**Stormwater Management Plan Checklist – Revised:**

**PPR 234 Subert Ranch Sand Pit**

**Date: 2/1/2024**

**4**  
SHEET 4 of 5

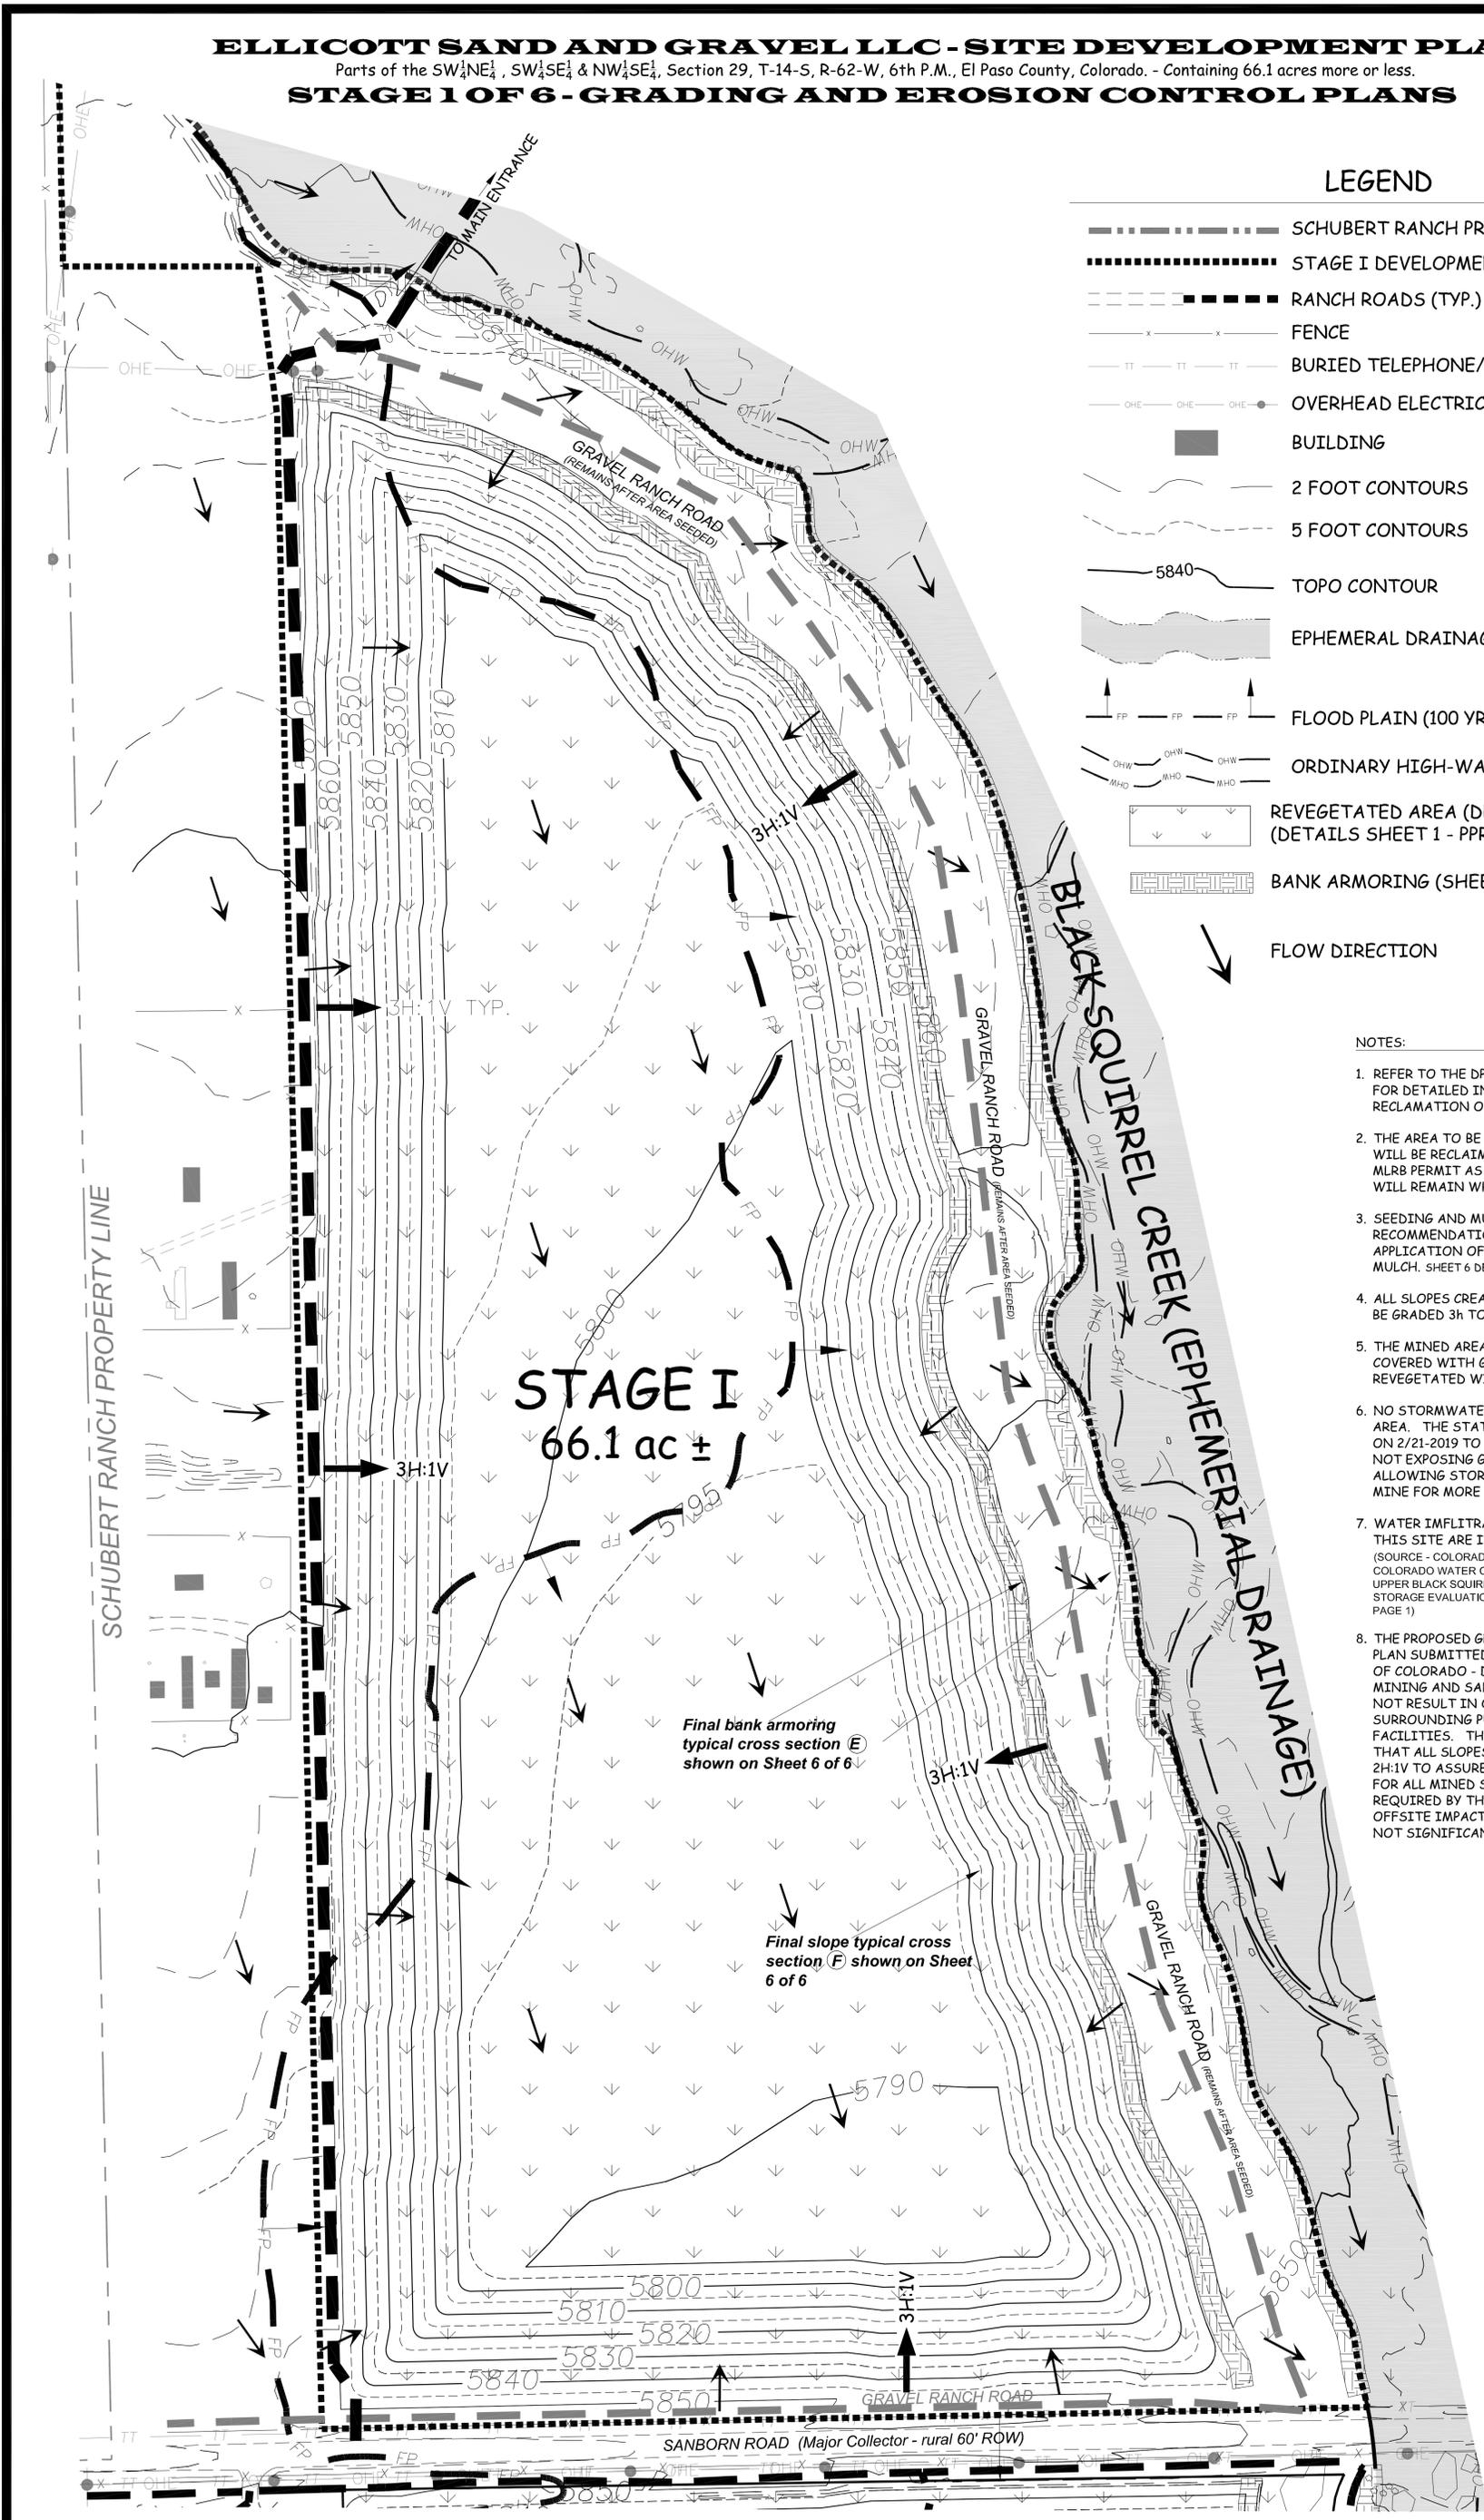
1.23. It is our understanding that the requirement of 70% pre-disturbance density only applies to areas outside of the affected area. Areas outside the affected area are not subject to site reclamation. What vegetation density is outside the affected area, should meet the 70% pre-disturbance density. There is nothing we plan to do to affect that density, other than control of noxious weeds.
